Your Ref:
Our Ref: EN010139
Date: 08 March 2024

Application by RWE Renewables UK Solar and Storage Limited for an Order Granting Development Consent for the Byers Gill Solar project

Advice following issue of decision to accept the application for examination

**Public Rights of Way Key Plan  
APFP Regulation 5(2)(k)**

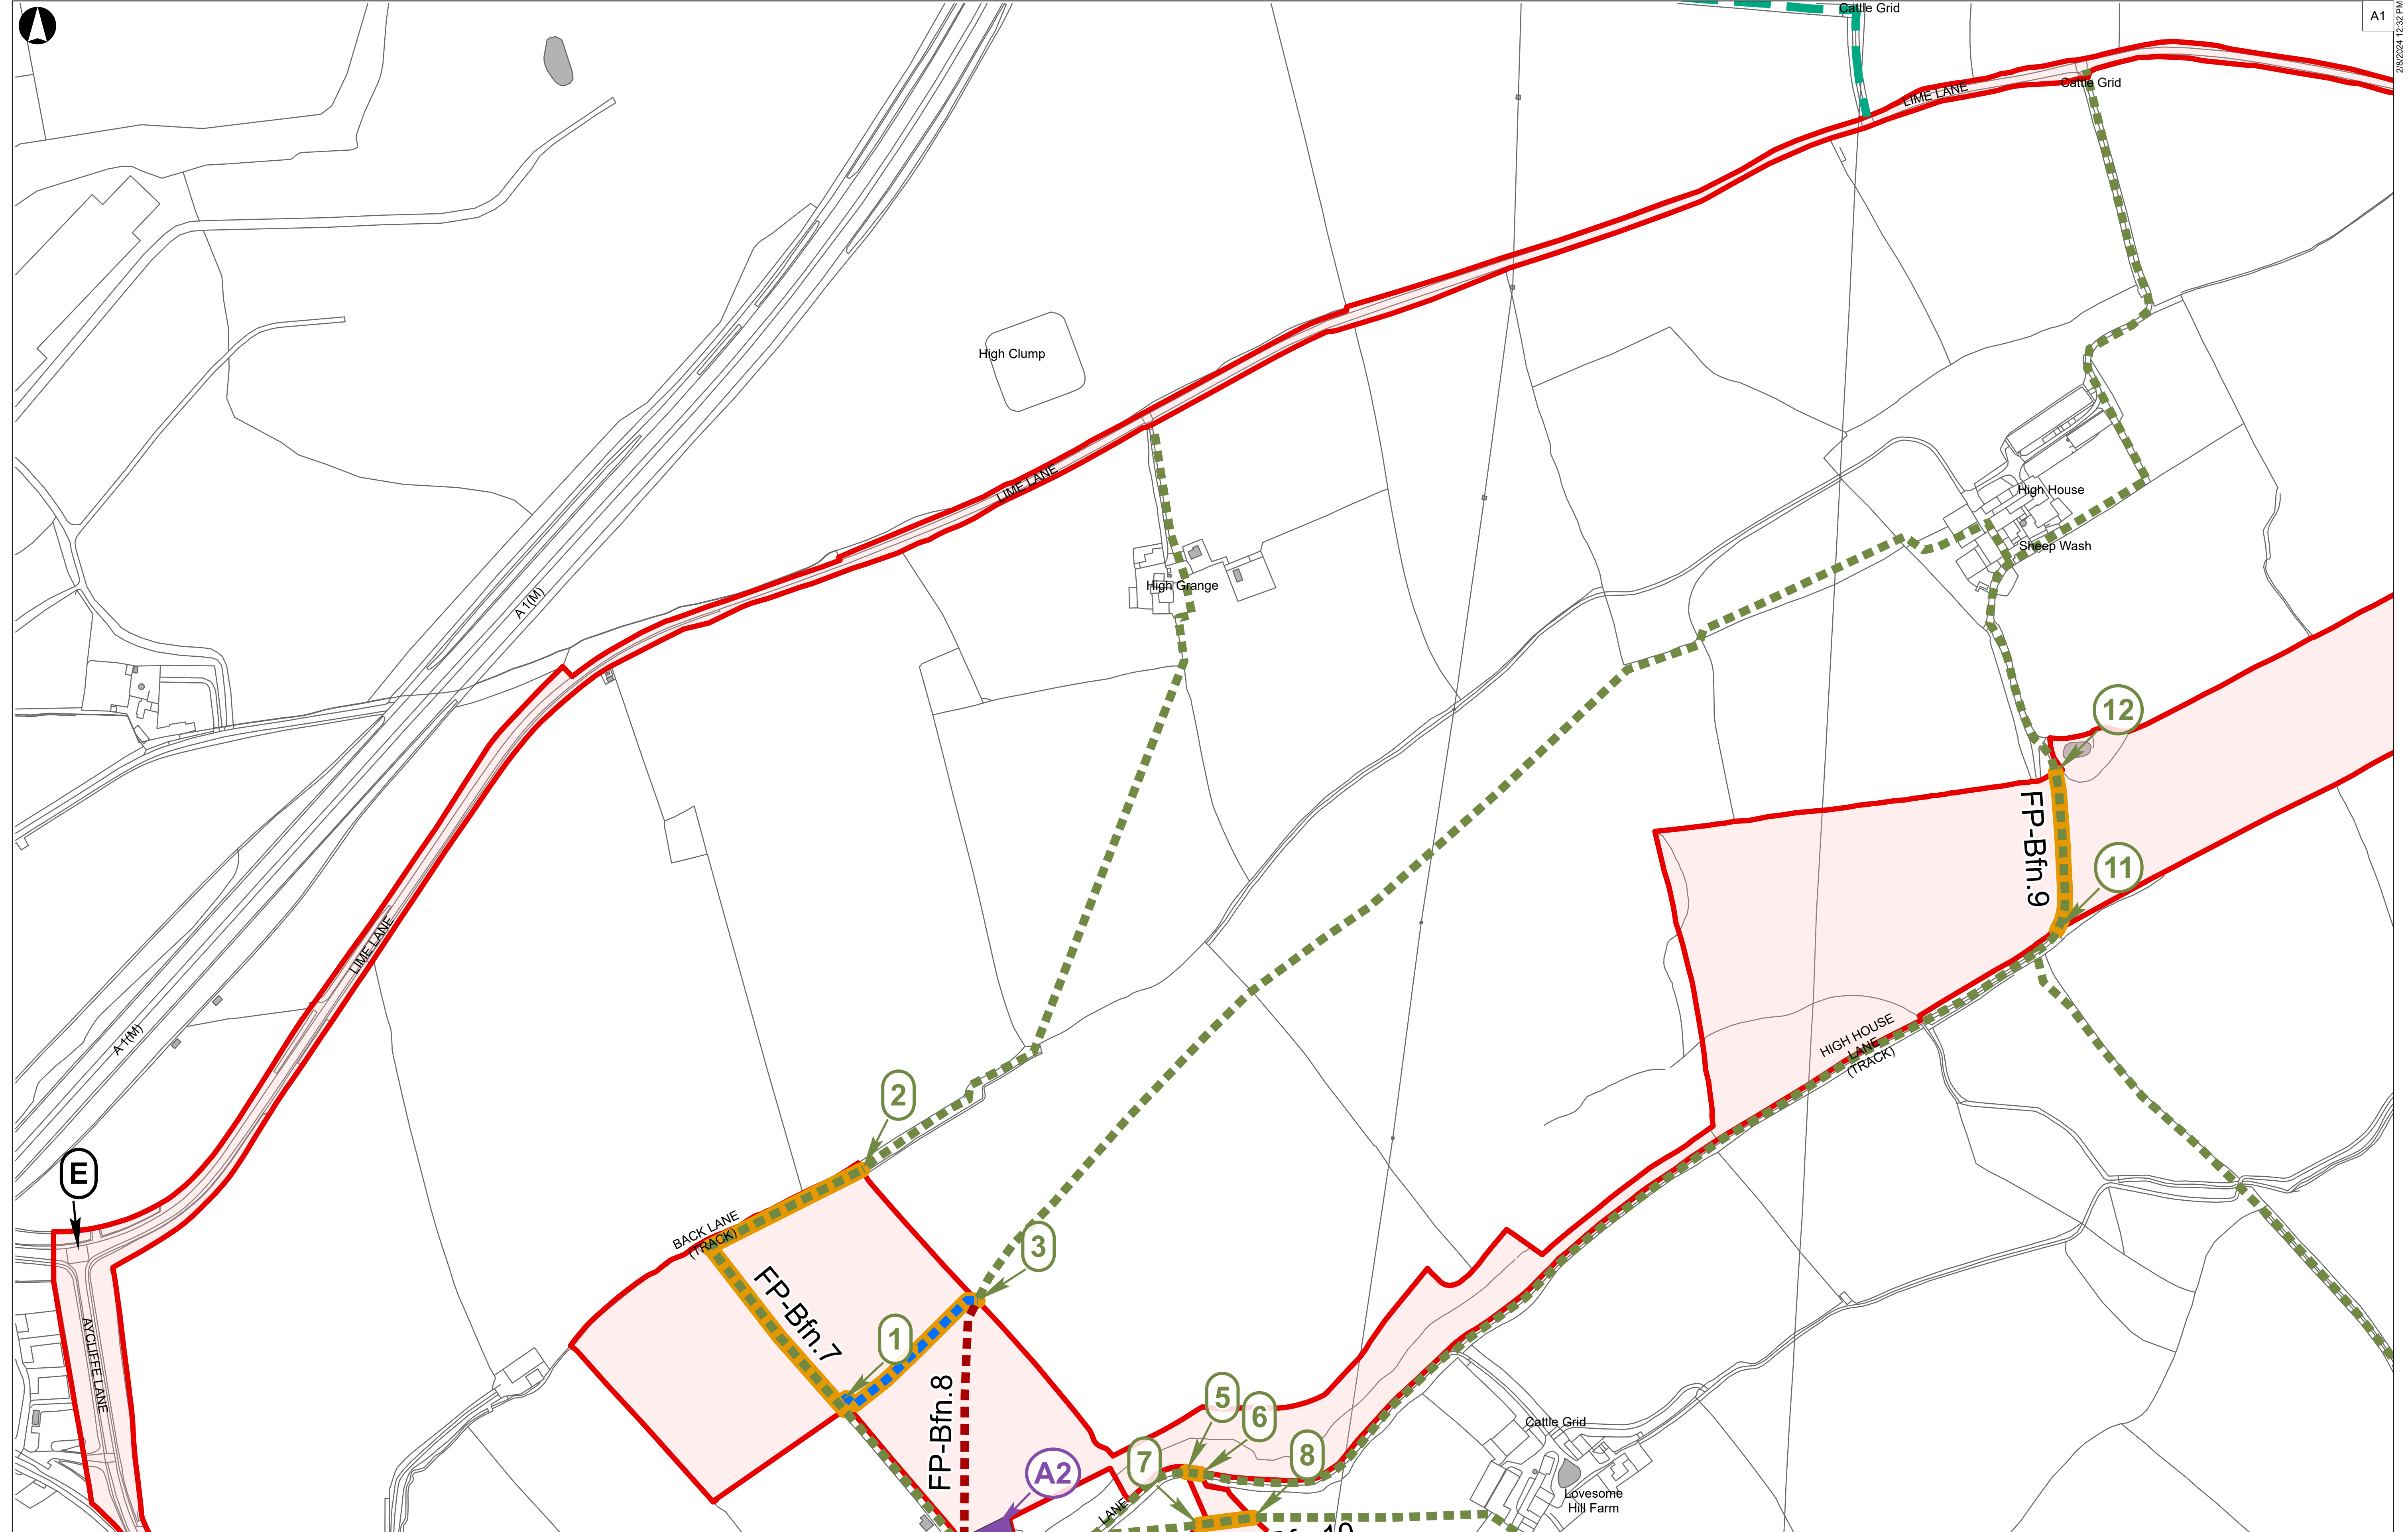
The order of the sheets in the **Street Works, Rights of Way and Access Plans** is not consistent with that of the Key Plan included in the **Works Plans (Doc 2.2)** or the **Land Plans (Docs 2.4)**. In addition, the **Street Works, Rights of Way and Access Plans** does not appear to actually match the layout of the key plan and does not appear to correspond to the order in which the sheets of the **Street Works, Rights of Way and Access Plans** are actually set out.

Sheet 7 of 13

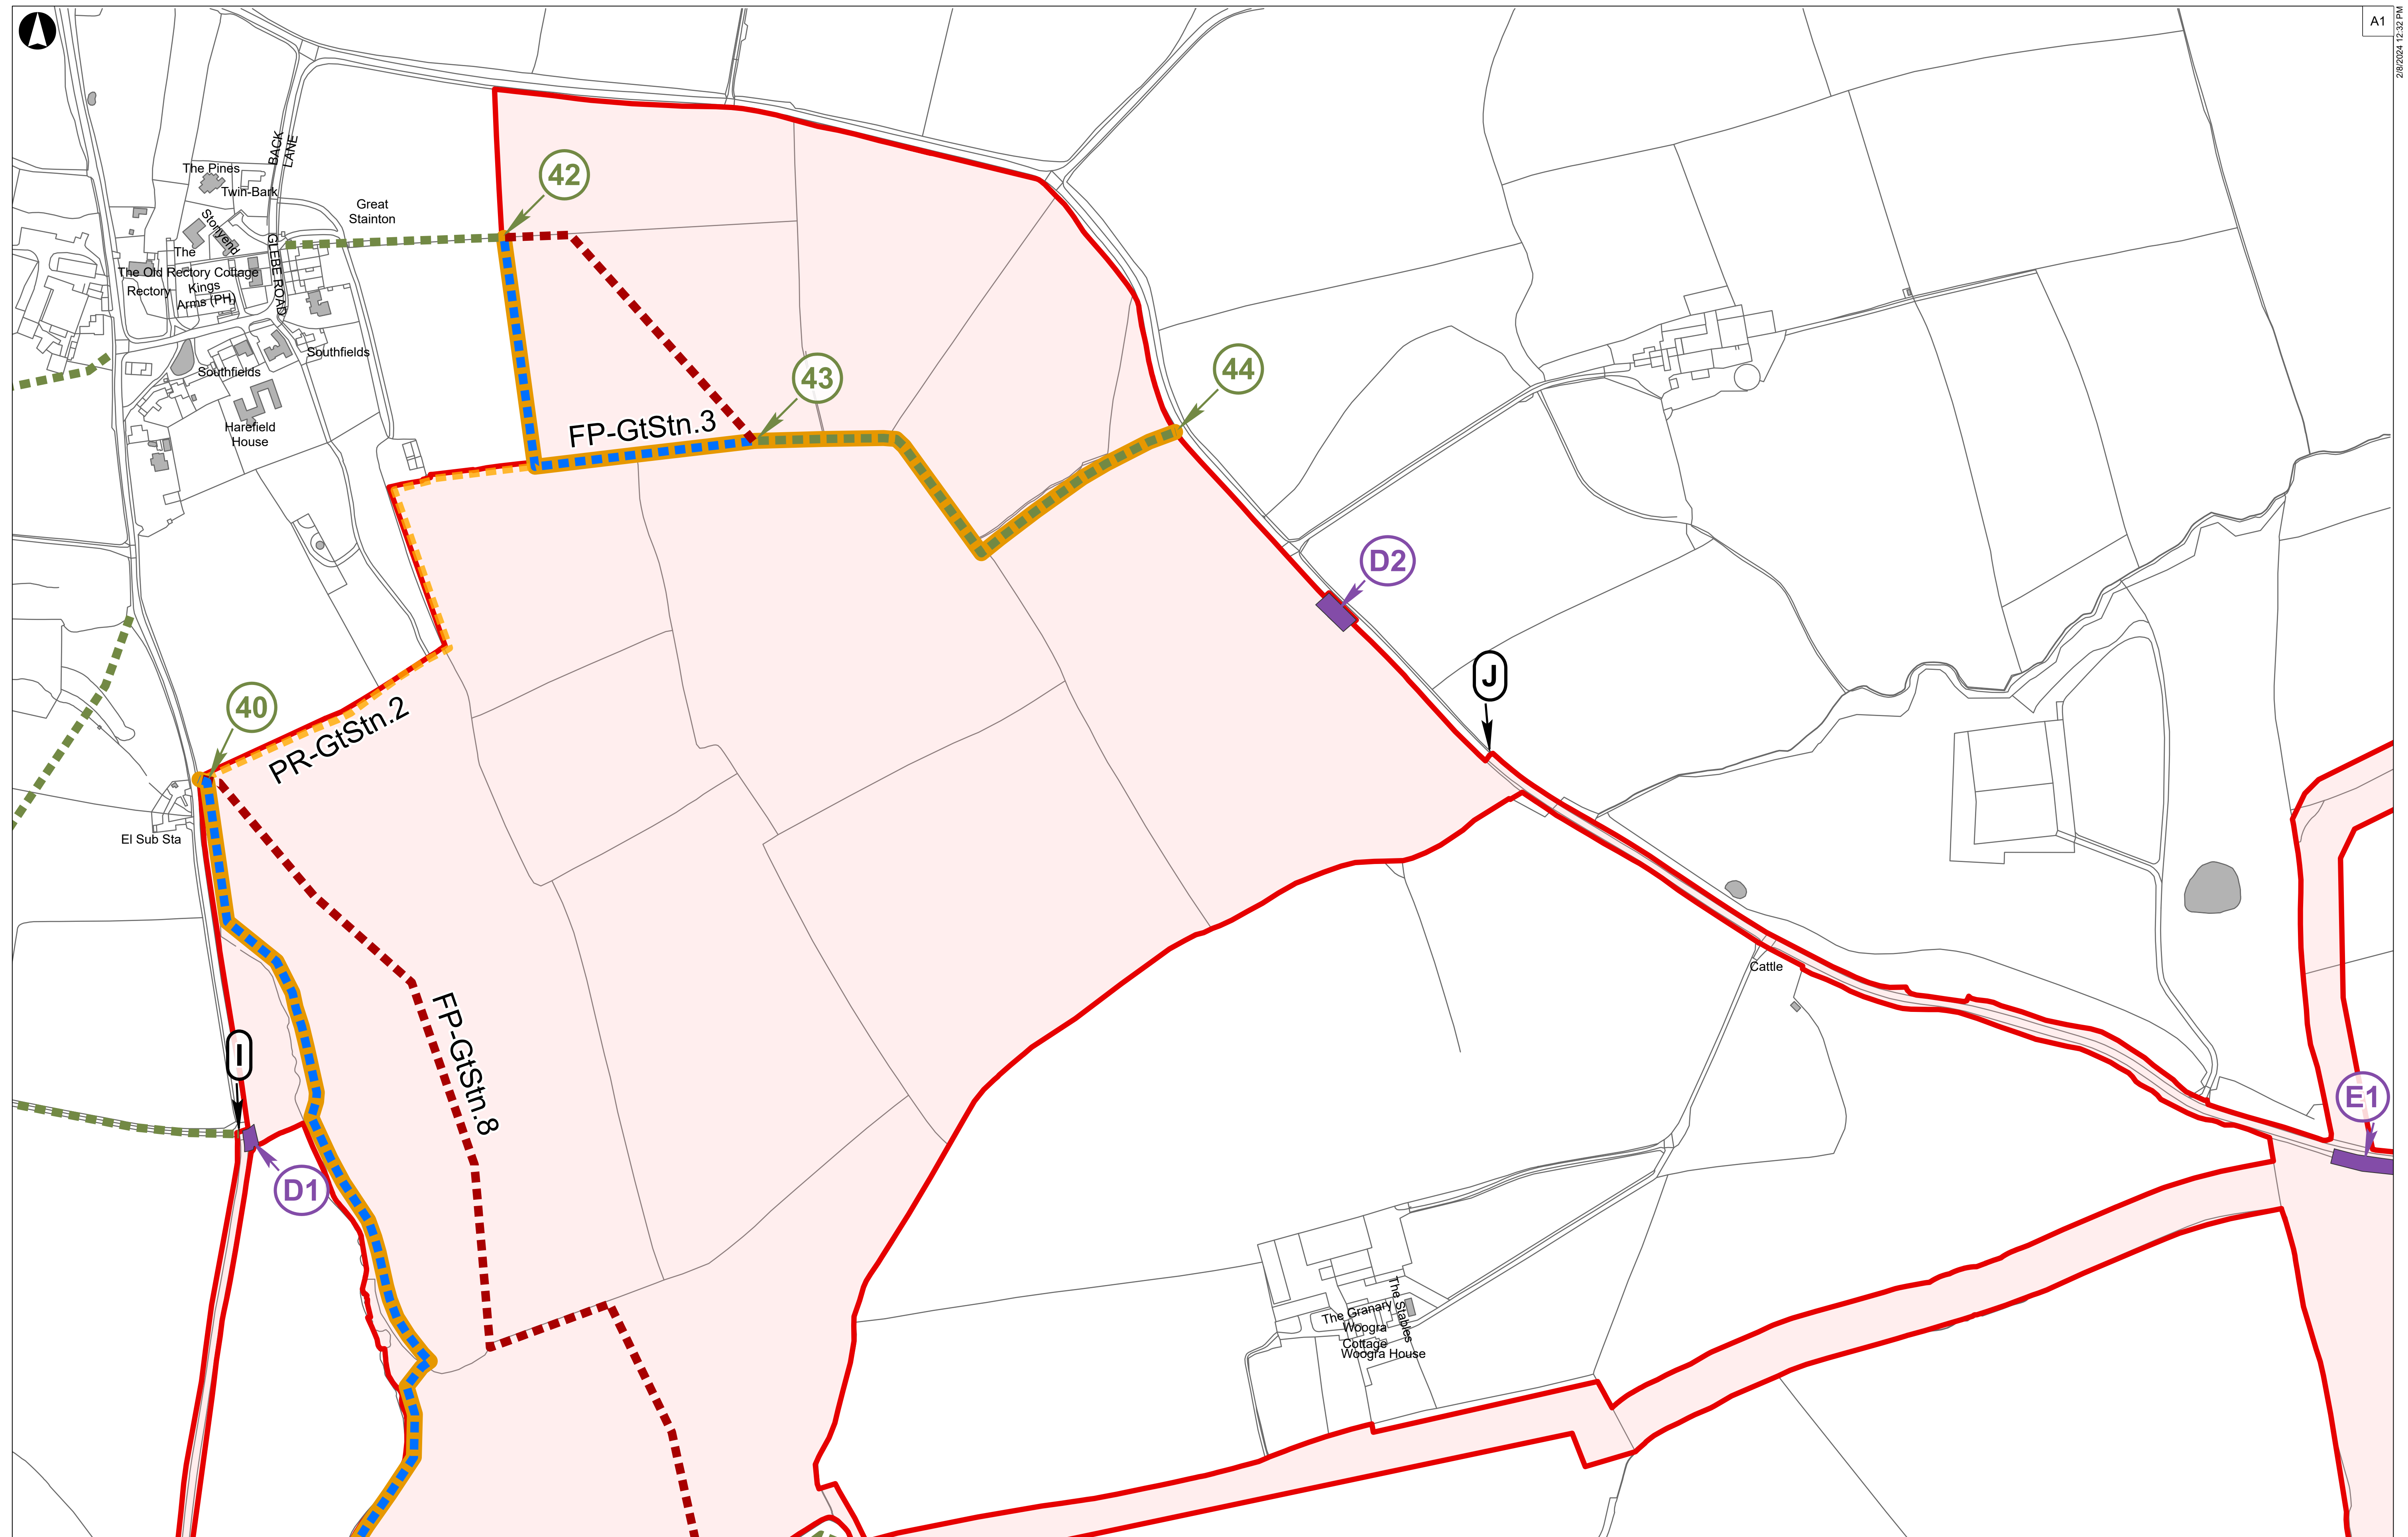
The Inspectorate notes that there appears to be a lack of consistency across the plan sheets regarding street names and additionally there are some named streets which are referenced in the **draft Development Consent Order** that do not appear to have been labelled on the plans, e.g. sheet 7 and 8, Elstob Lane. The Applicant may wish to review the **Street Works, Rights of Way and Access Plans** and amend to ensure consistency and that all roads listed are labelled across all plans.
